Land at Bilsham Road, Yapton
Planning Reference: Y/70/22/DOC

Approval of details reserved by condition imposed under ref Y/91/17/OUT relating to Condition Nos 9 - surface water drainage

At this stage we would not recommend that the condition is discharged until further information as outline below is resolved and provided:

CLASS S PIPE BEDDING & SURROUND (NTS)
CLASS Z PIPE BEDDING & SURROUND (NTS)

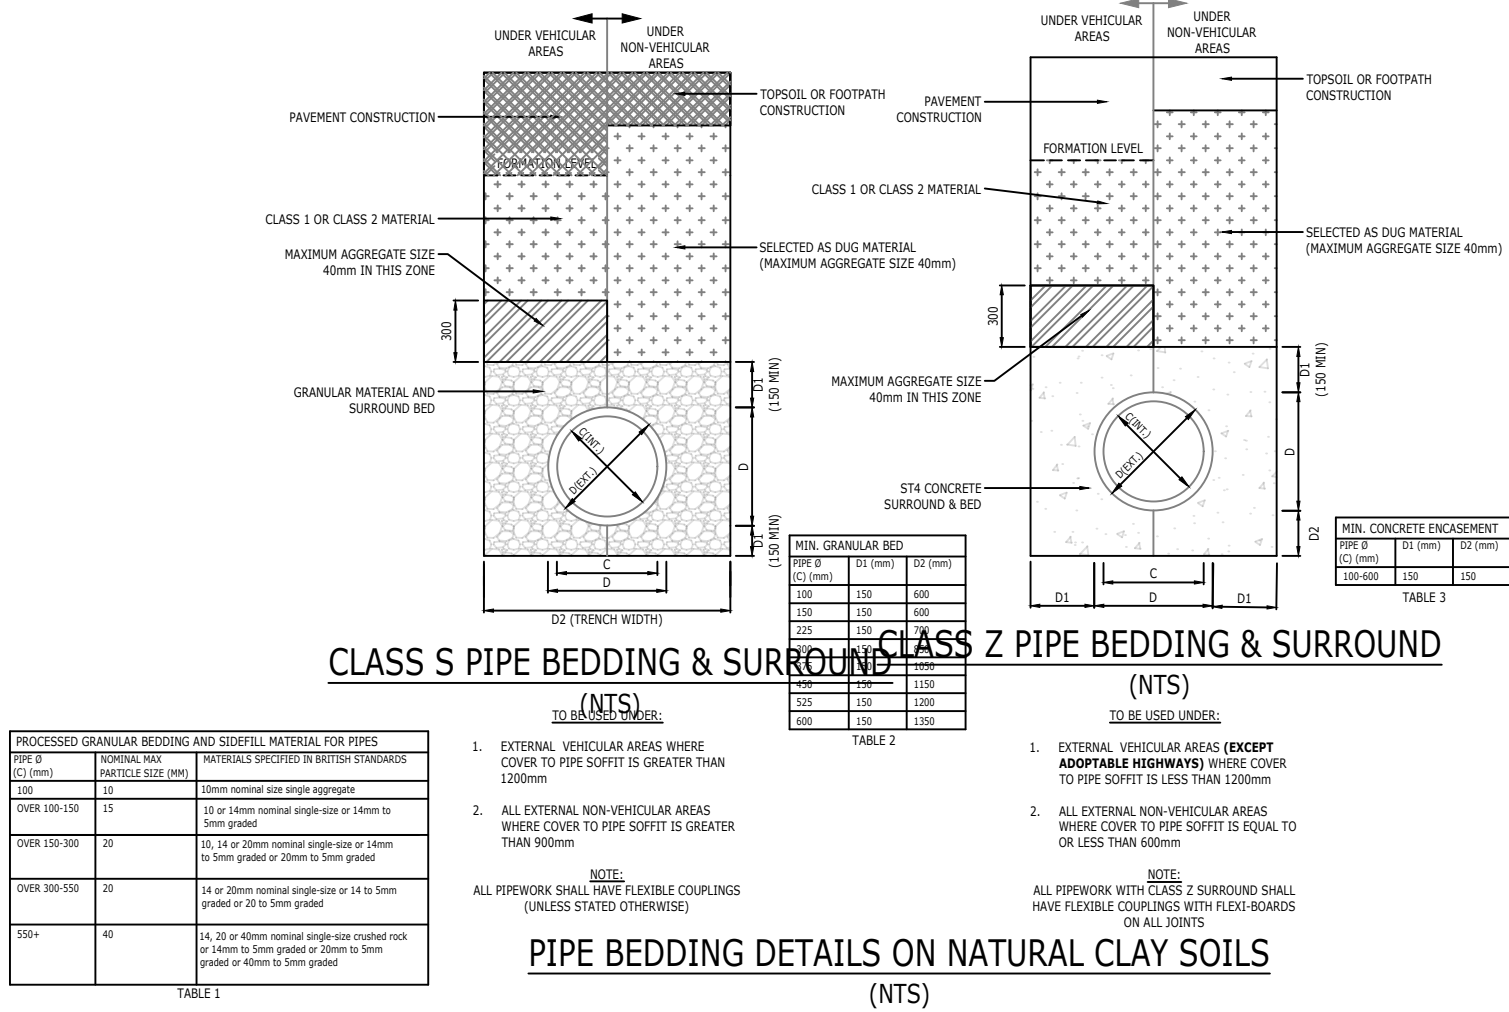
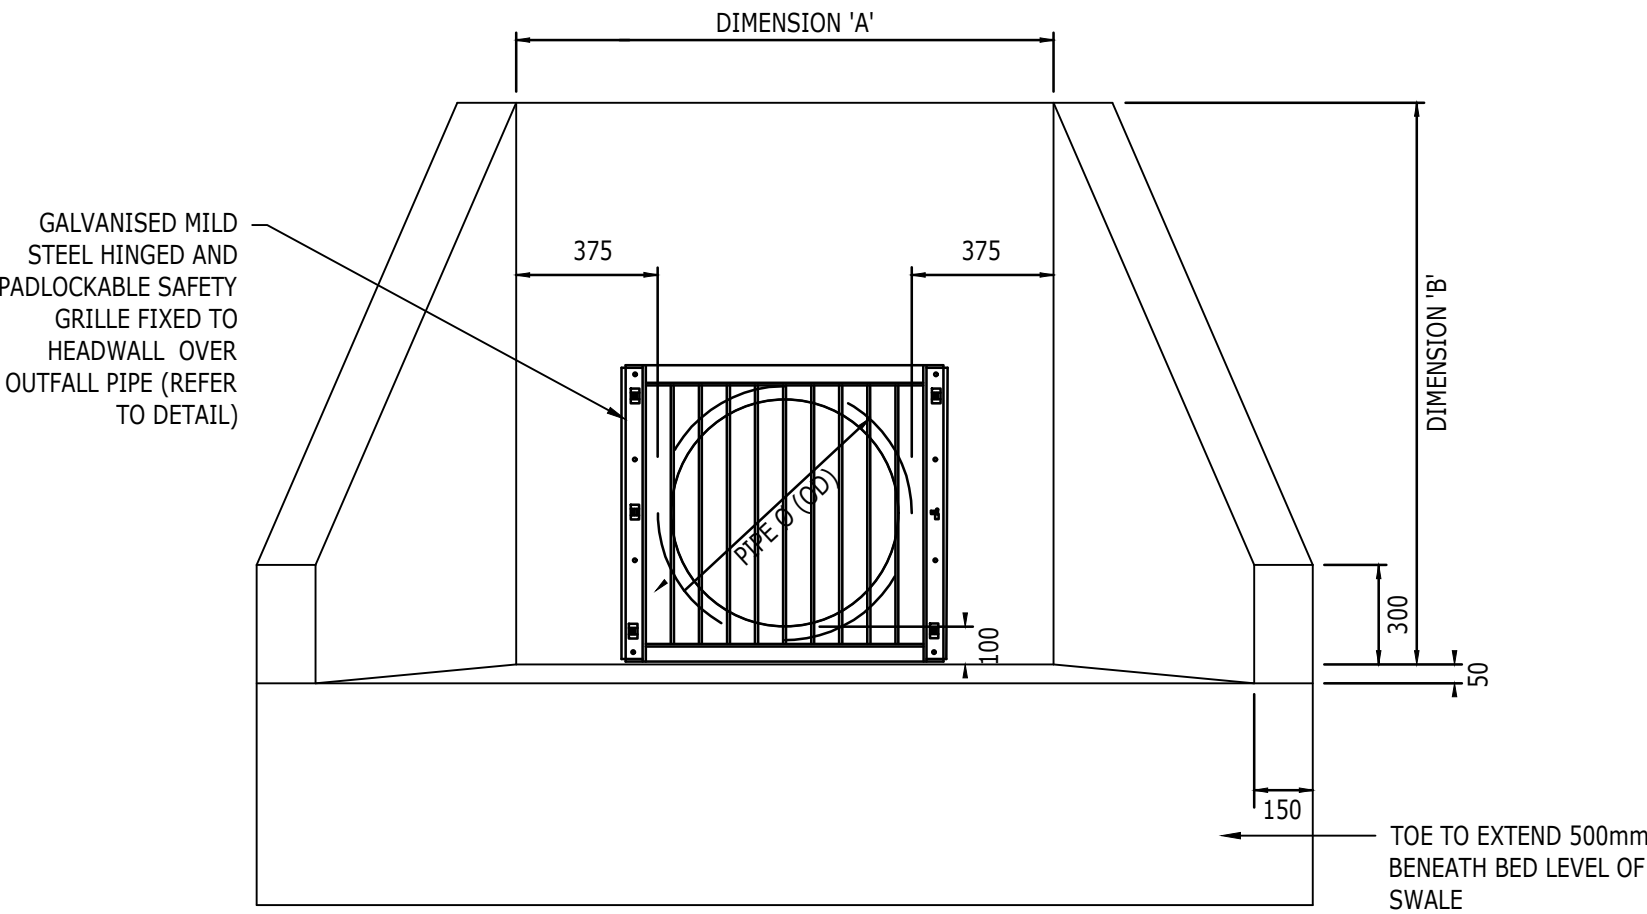
10. *Please detail proposed outfall inverts, along with invert of culvert at the proposed points of connection. Connection should be made soffit to soffit.* Currently not shown on the drawings. The covering letter highlights that this is provided on the details drawing D1956-15-100 which formed part of the previous application, in which case this should be resubmitted with this current application as well for review

11. *Please provide cranked grilles at a 45 degree angle.* - Cranked grilles required on heads – S104 Construction details sheet 1 of 2 D1956-15-100 needs to be updated to suit ADC requirement. Pipe beddings details on this drawing are illegible in parts. Information needs to be clearly presented. We note that applicant’s response that this is not “DSG compliant” however the drawings refer to Sewers for Adoption 7th Edition. As such the applicant needs to be clear which edition of Sewer for Adoption the adoptable drainage is being designed to. In addition they should confirm who the adopting authority will be as well as confirmation from the adopting authority on whether they will or will not accept cranked grilles.
